PORTLAND MAINE

June 9, 2011

Re: 68 Codman Street – 128 A013 – R-3- replace rear deck - permit #2011-06-1249

PLOT  
PLAN

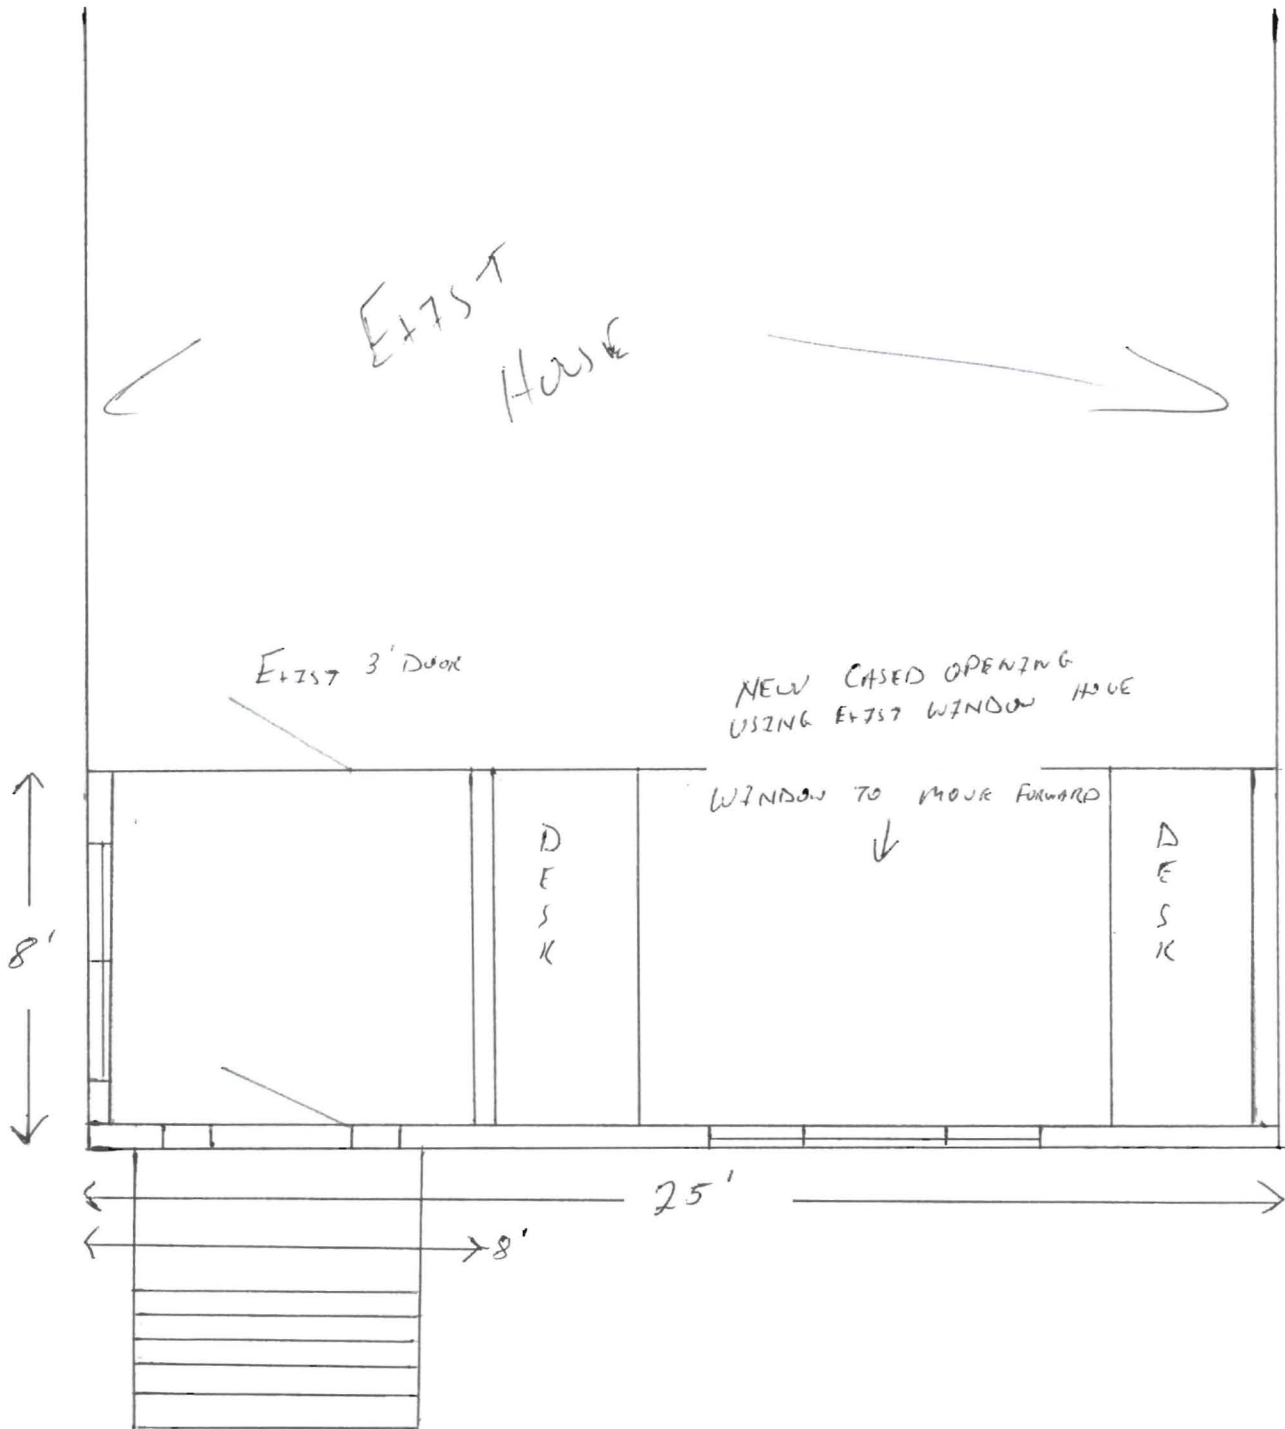
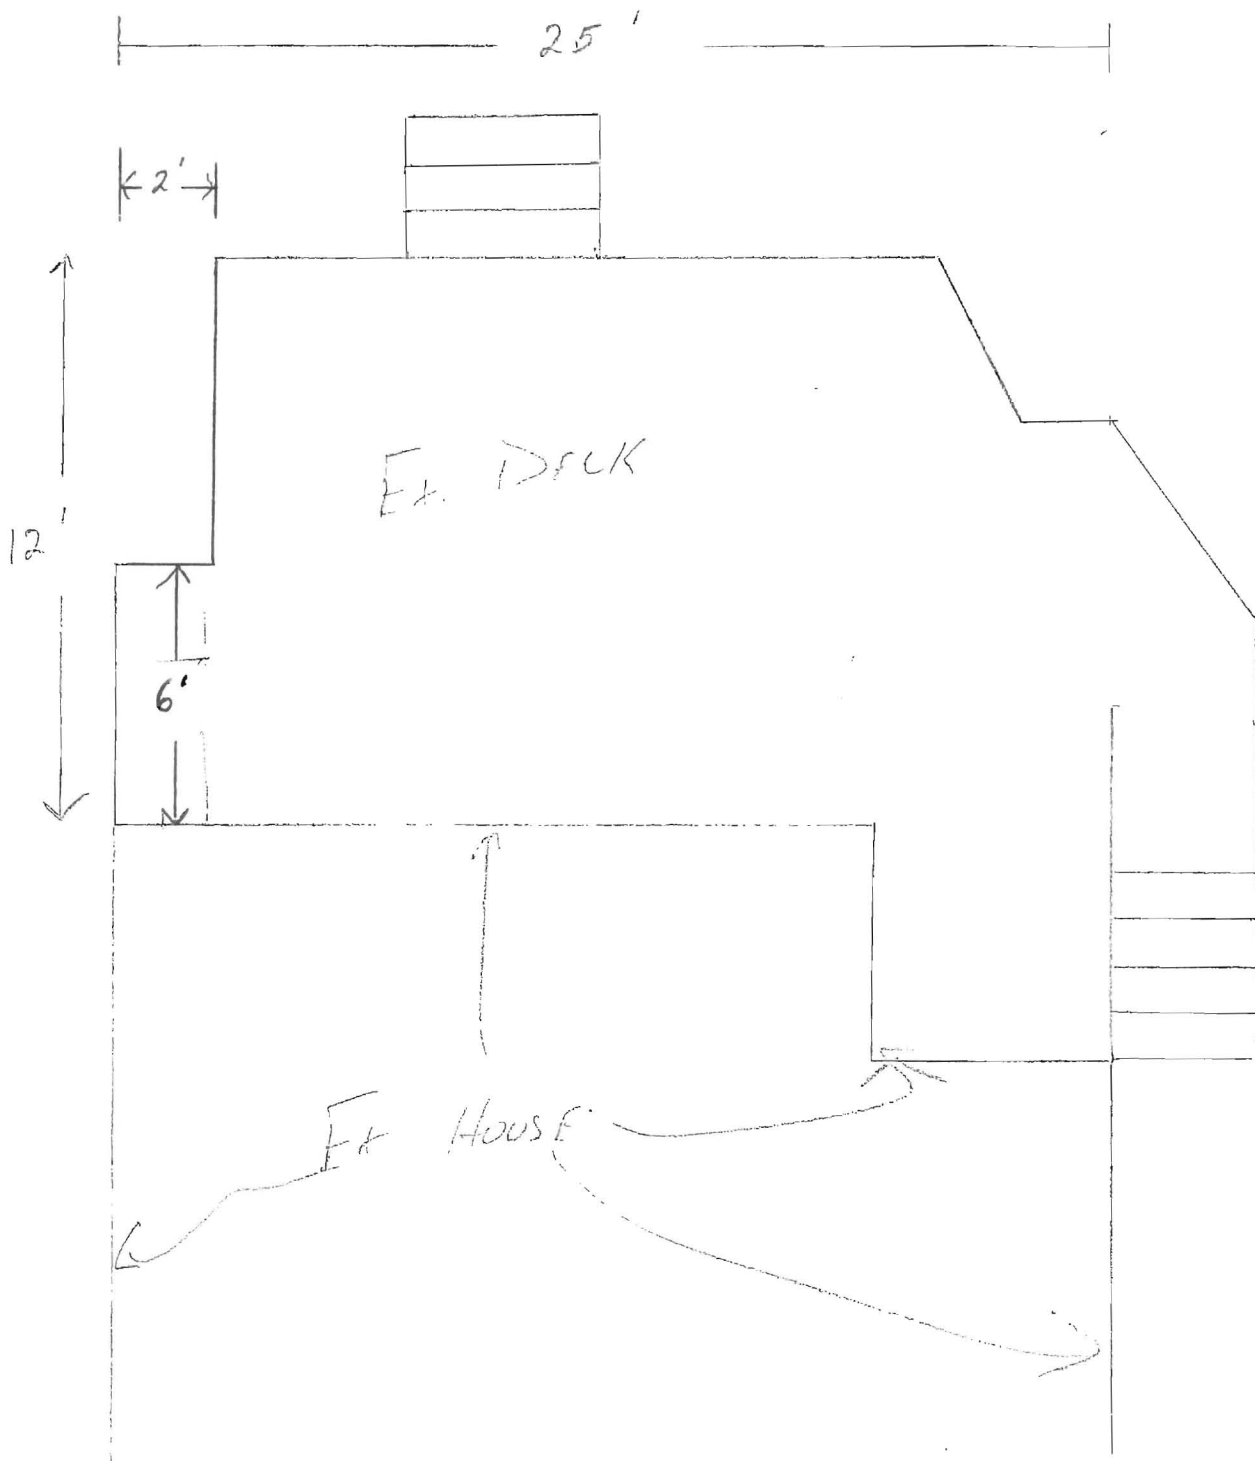
I have reviewed your permit application to rebuild the rear deck and front sun porch at 68 Codman Street. At this point I must deny your permit because the rear deck was not permitted, and it does not meet the required setback.

68 Codman is located in the R-3 residential zone. The minimum side setback for a one story addition is eight feet [section 14-90(d)(3)] . The distance given on the plot plan from the deck to the side property line is six feet. I researched our records to see if the existing rear deck had been permitted and it had not. If the deck was not permitted, it is not legal. Since it does not meet the side setback, it needs to be brought into conformity. You have thirty days to bring the deck into conformity. You may either revise the existing application to have the deck meet the eight foot side setback or you need to remove it.
